From: Simon Davis
Sent: 05 March 2019 17:49
To: Planning.Responses
Cc: Martyn White
Subject: FW: BR/326/18/PL - The Royal Hotel, The Esplanade, Bognor Regis
Attachments: 169 3.106 Rev 02 Proposed Roof Plan.pdf; 169 3.105 Rev 01 Proposed Fourth Floor.pdf

From: Stephen Brooker [REDACTED]
Sent: 05 March 2019 17:33
To: Simon Davis [REDACTED]
Subject: RE: BR/326/18/PL - The Royal Hotel, The Esplanade, Bognor Regis

CLIENT	Metamorph Management LLP
PROJECT	The Royal Hotel Apartments
DATE	December 2018
DRAWING TITLE	Proposed South Elevation

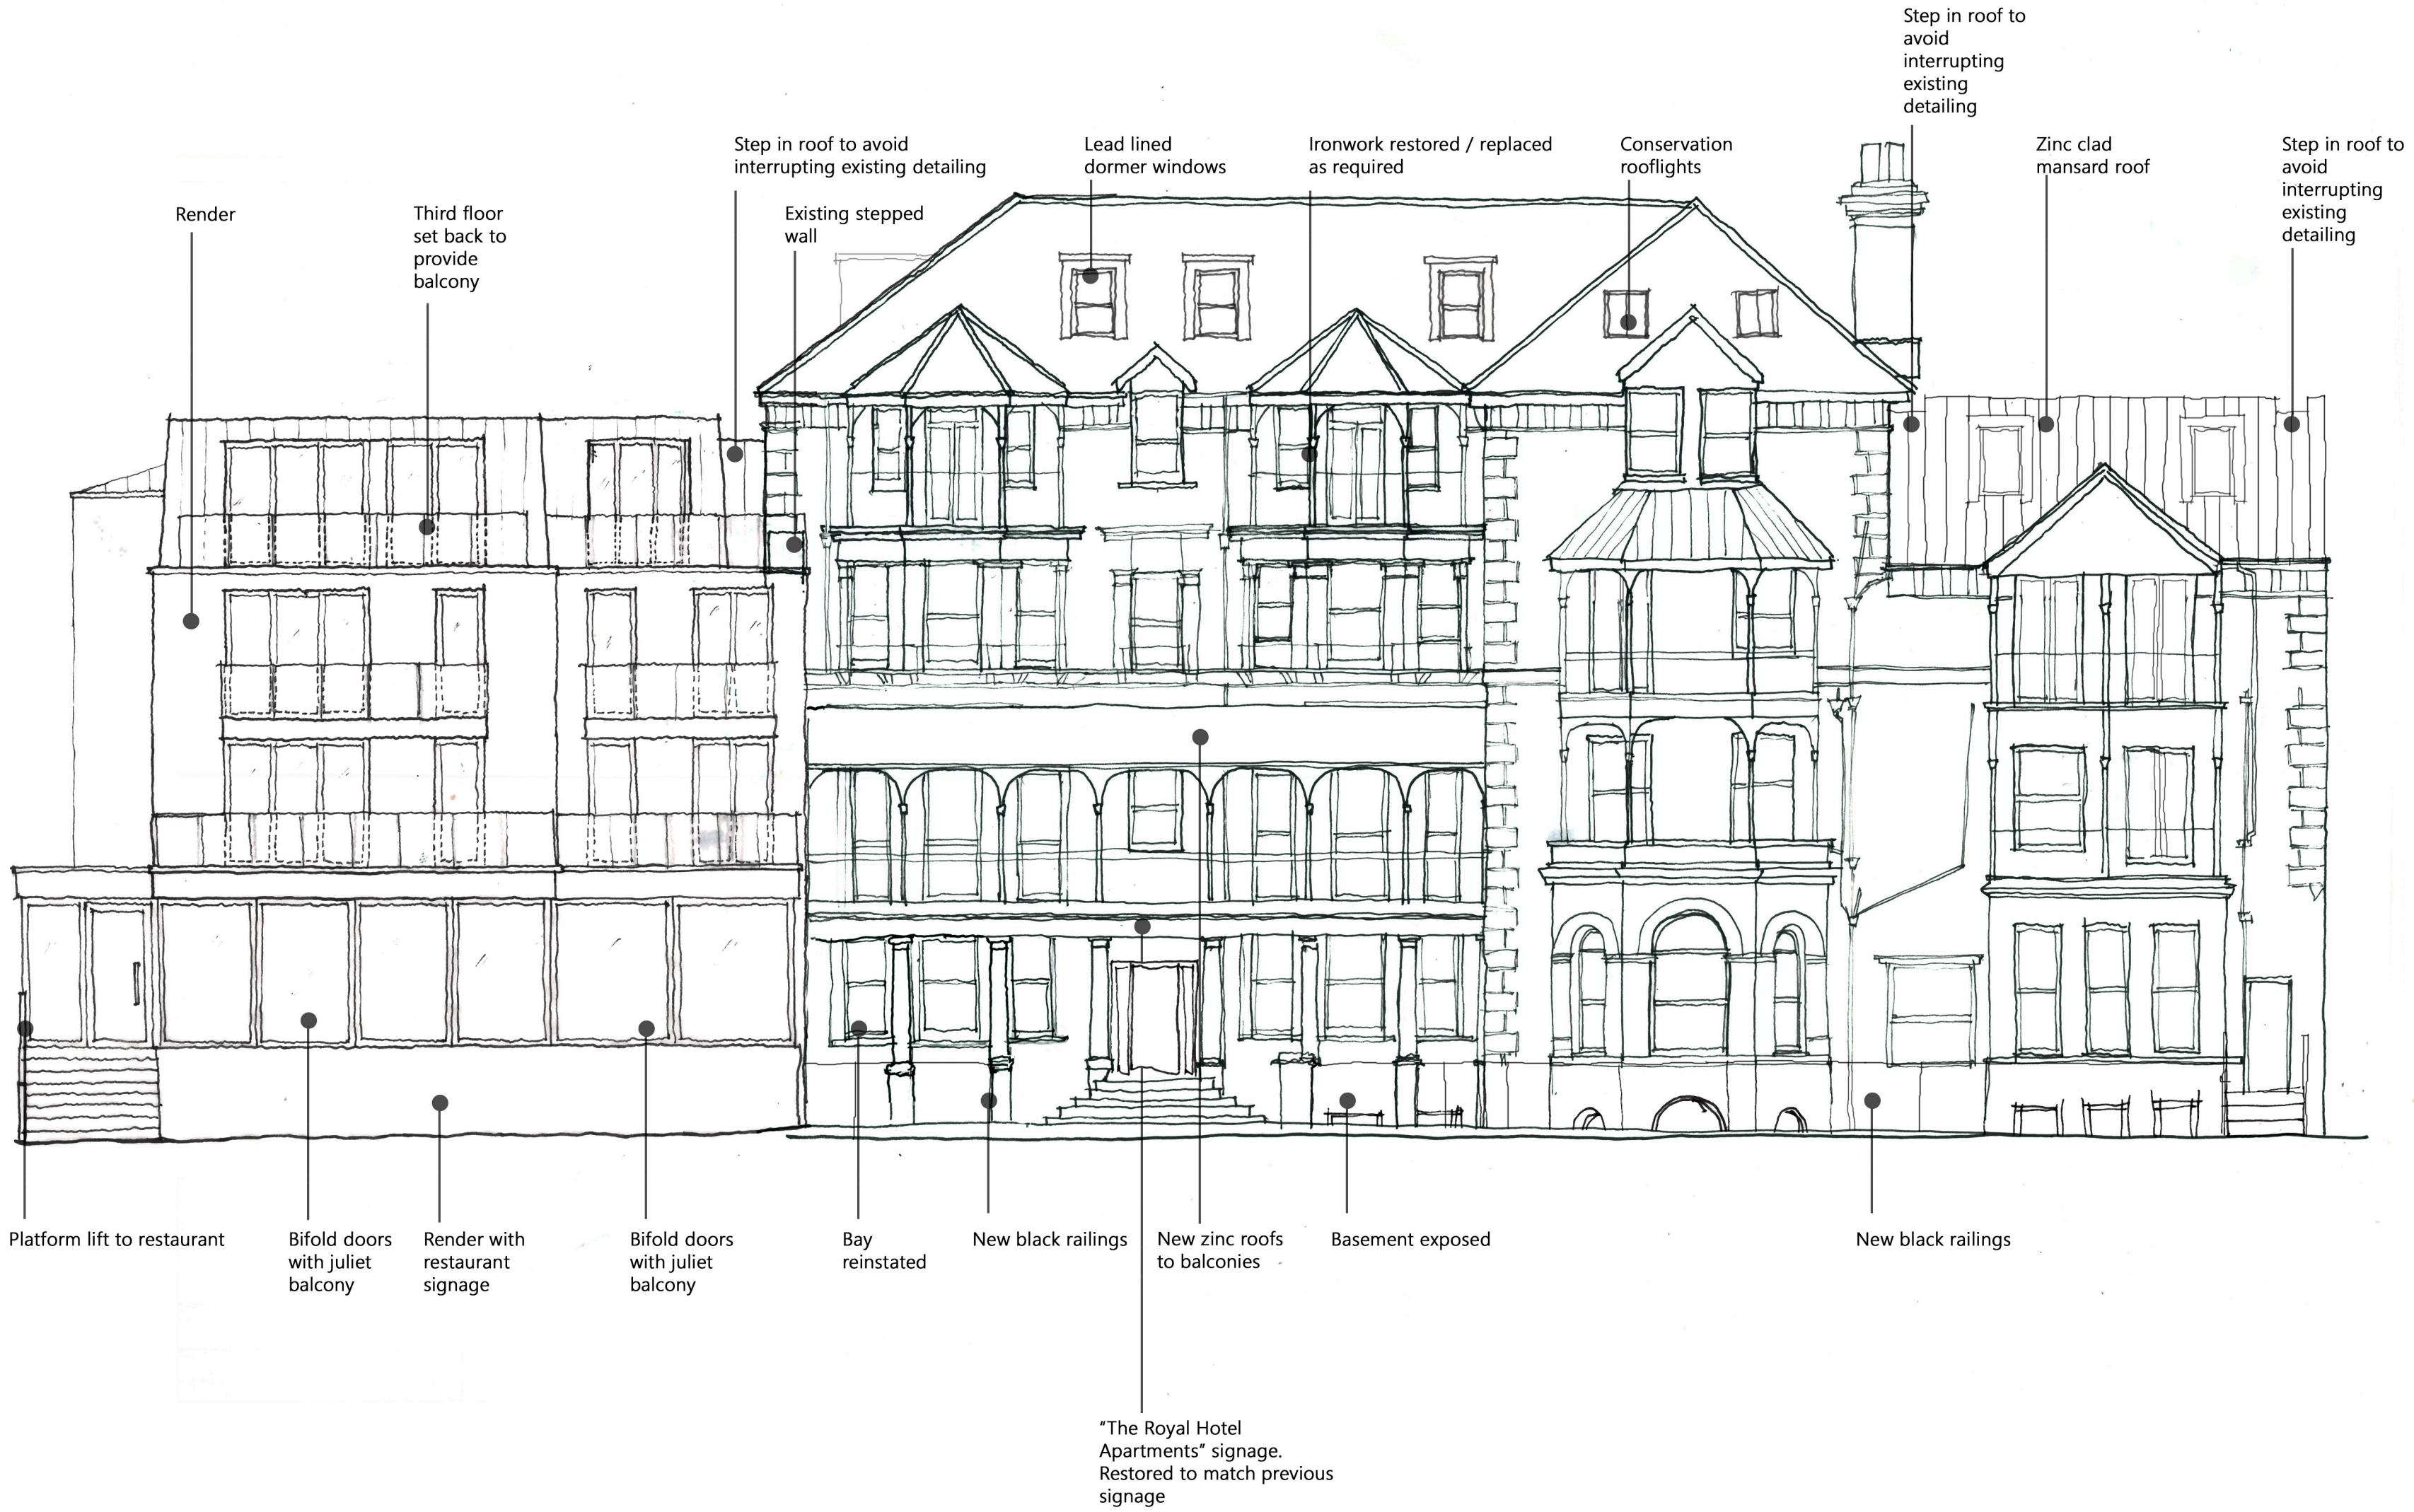
Separately, please see two annotated plans attached. On the roof plan (block plan), it looks like there is a dormer on the eastern flank of the main roof and this is not shown on the N or S elevations. It may be that the missing dormer is actually a velux or the position of the chimney though (as I don't have the fourth floor plan, I haven't been able to check). Also there is a conservation rooflight shown on the N elevation of the main roof but not shown on the roof plan.

The square shape on the roof plan on the eastern roof slope was not a proposed dormer, it is the chimney (now labelled as such) which means no need to alter the elevations or 4th floor plan to show it. The roof plan has also been altered to show the rooflight shown on the north elevation.
